TIERRA WEST, LLC

January 25, 2024

**RE: 2023018 SAGE PLAZA STORAGE
EROSION AND SEDIMENT CONTROL PLAN**

Per the correspondence dated January 9, 2024, please find the following responses addressing the comments listed below:

Drawing file: ESC / ESC Plan 24.01.25.pdf

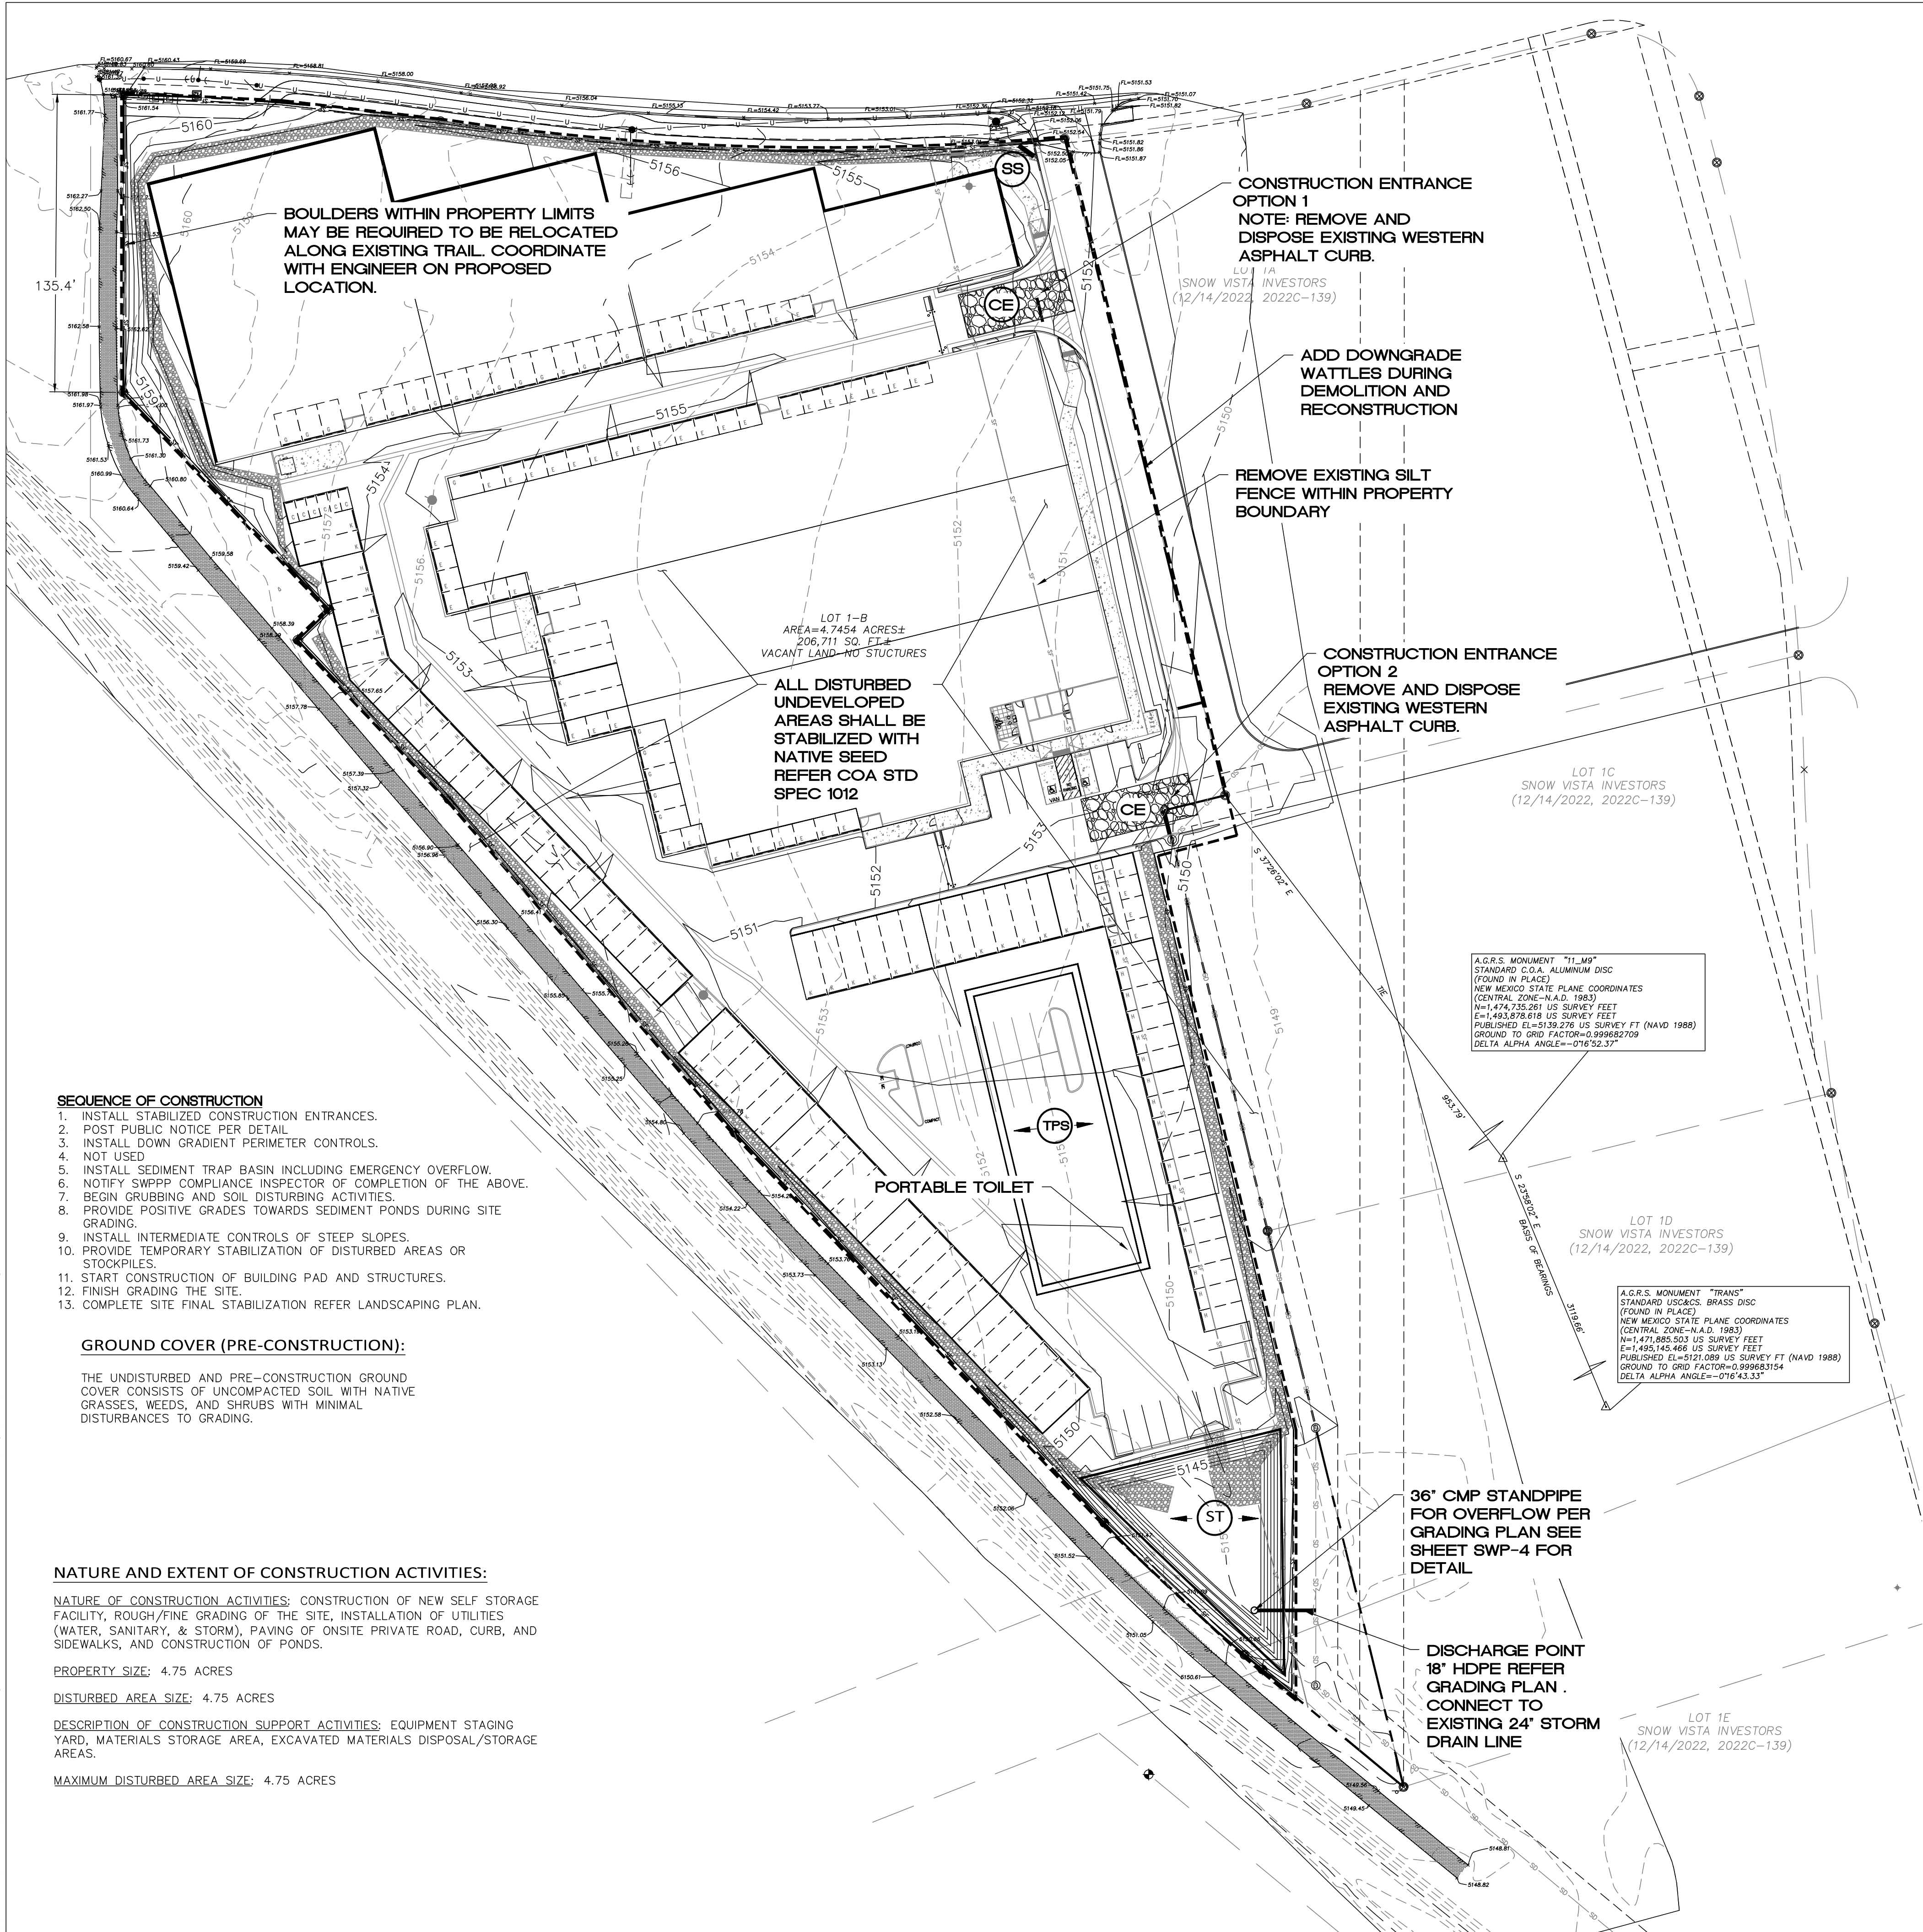
Response: Please see attached NOI.
3. The ESC Plan can't be approved until after Hydrology approves the G&D Plan for each specific purpose, Site Plan, Grading, Building Permit, and Work Order. The only purpose Hydrology has approved so far is Site Plan. The existing and proposed grades must be shown on the ESC Plan, and they must agree with the Grading Plan approved by Hydrology (CGP7.2.4.b.ii);

Response: Hydrology has approved the grading plan on January 18th, 2024.
4. The SWPPP must include site-specific interim and permanent stabilization per CGP 9.6.1.c.i. Provide a specification on the ESC Plan along with schedules for implementation per CGP 2.2.14. Label areas where existing vegetation is to be preserved and not graded at this time. Label areas to be stabilized with landscape rock (all areas in the public ROW) and show typical section and specifications. Label areas to be stabilized with vegetation and provide details and specifications.

5. Provide calculations for the Sediment Trap design showing compliance with CGP Part 2.2.12.c which requires storage for either:
 - A. The calculated volume of runoff from a 2-year, 24-hour storm; or
 - B. 3,600 cubic feet per acre drained.

Response: Calculation are included on sheet SWP-2.

CMP RISER DETAIL  
NTS

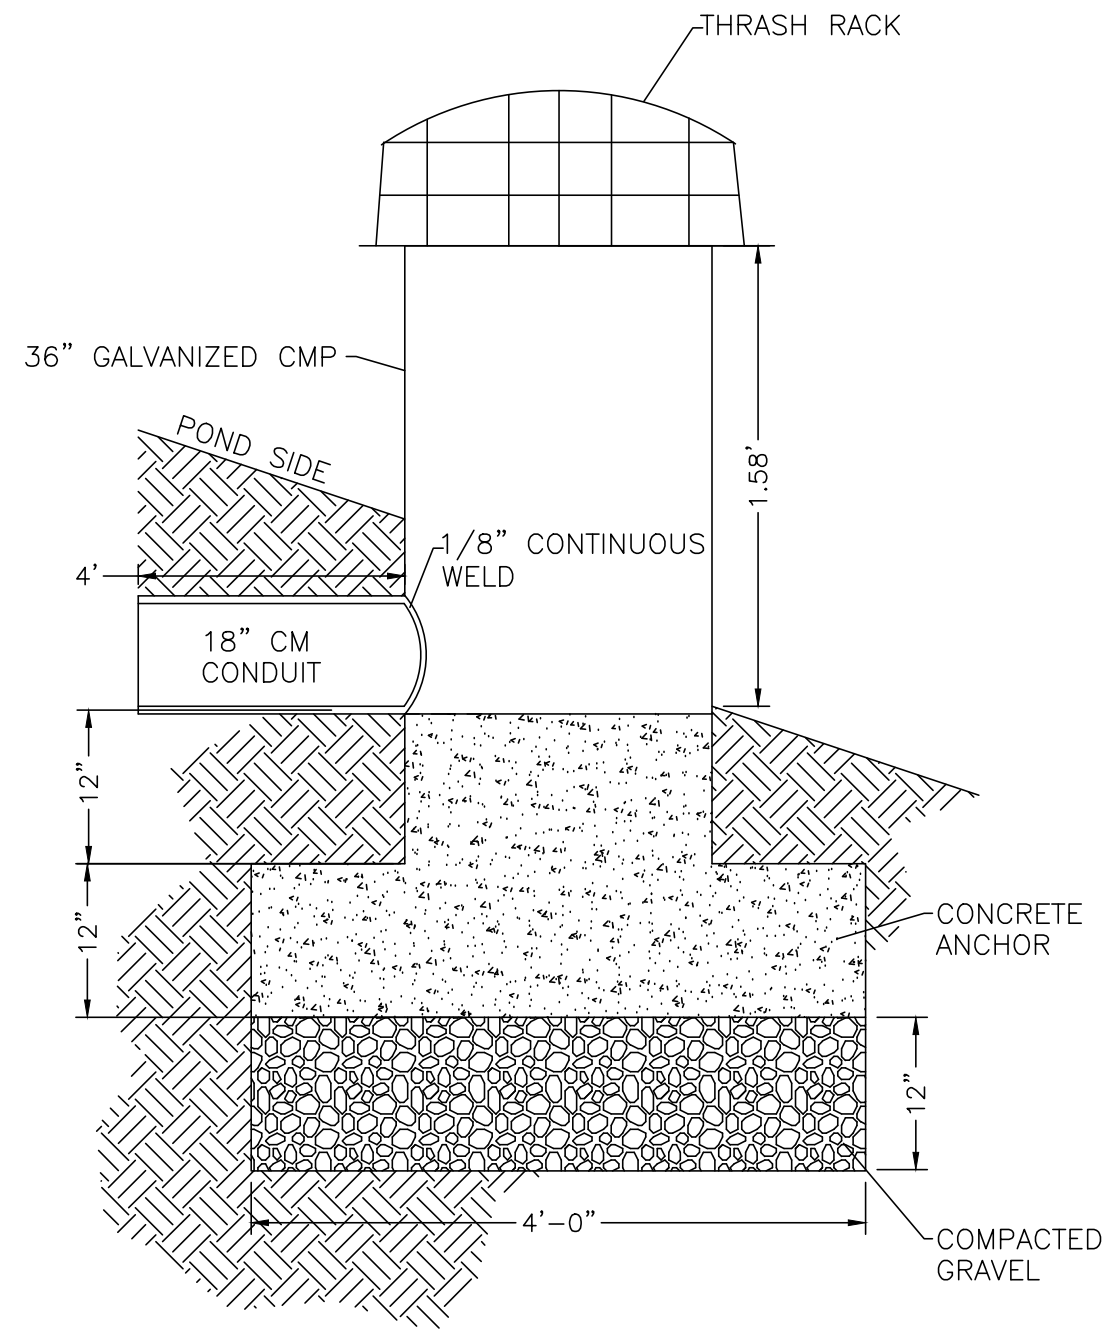
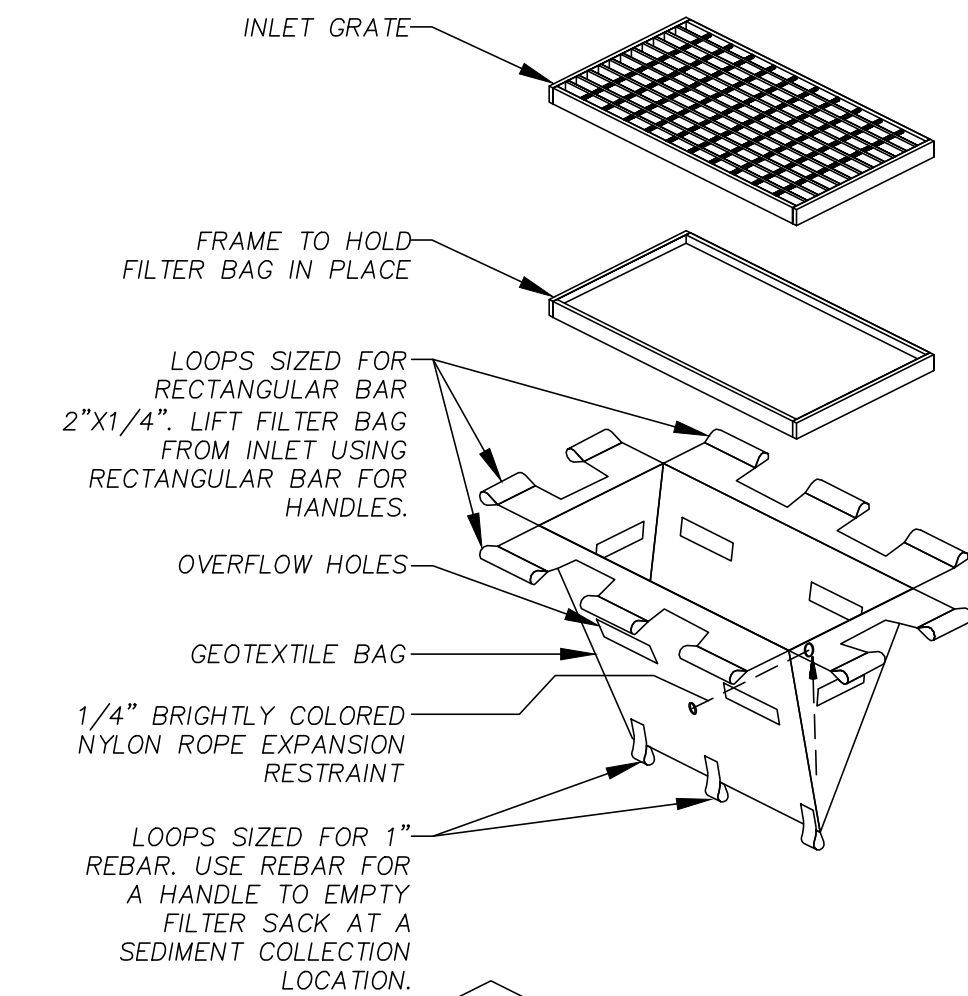
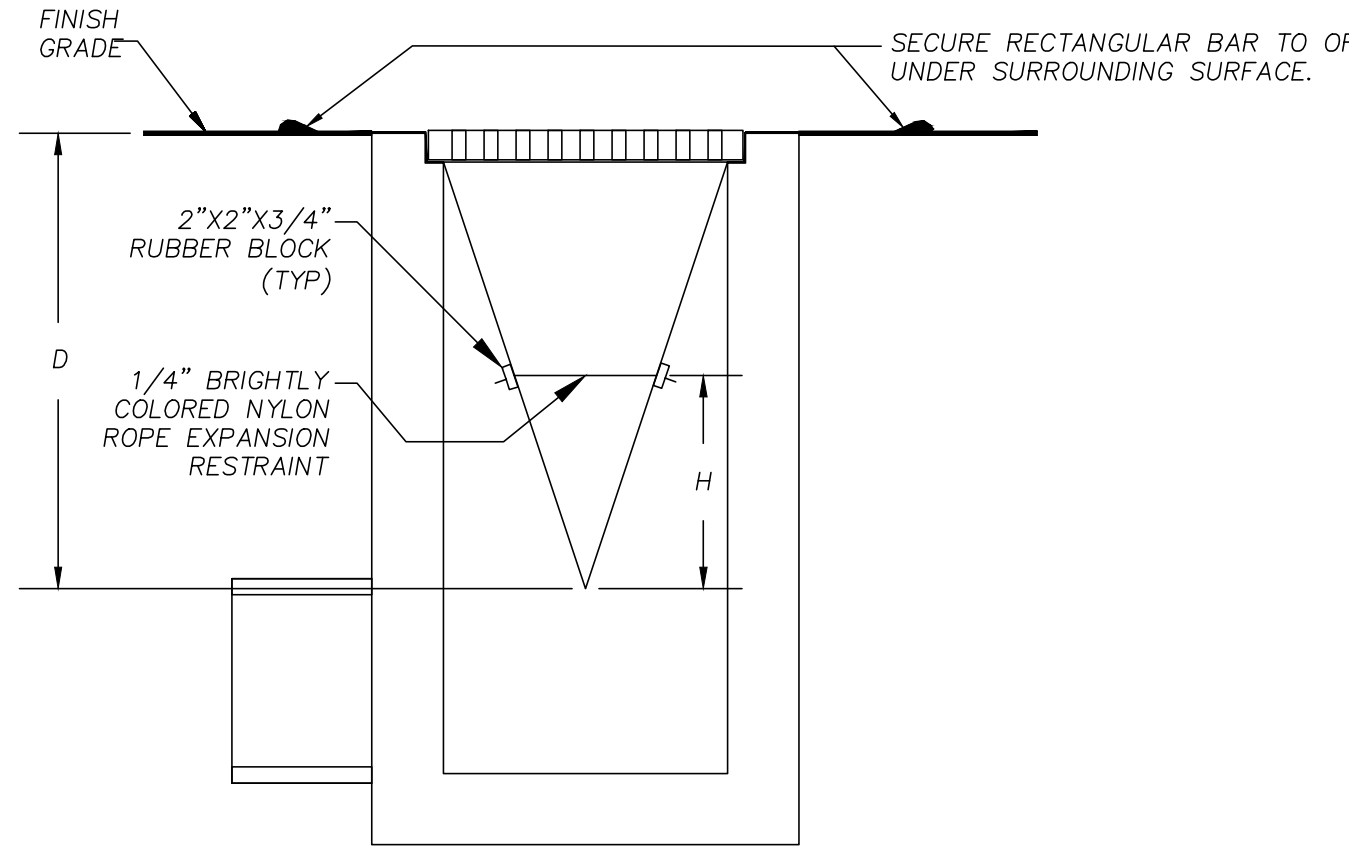
6. Provide details, including specifications for construction, inspection, and maintenance of erosion controls and velocity dissipation devices to prevent erosion at inlets and outlets of the sediment traps per CGP Parts 2.2.12.e and 9.6.1.c.i.

Response: See ESC notes and BMP maintenance notes.
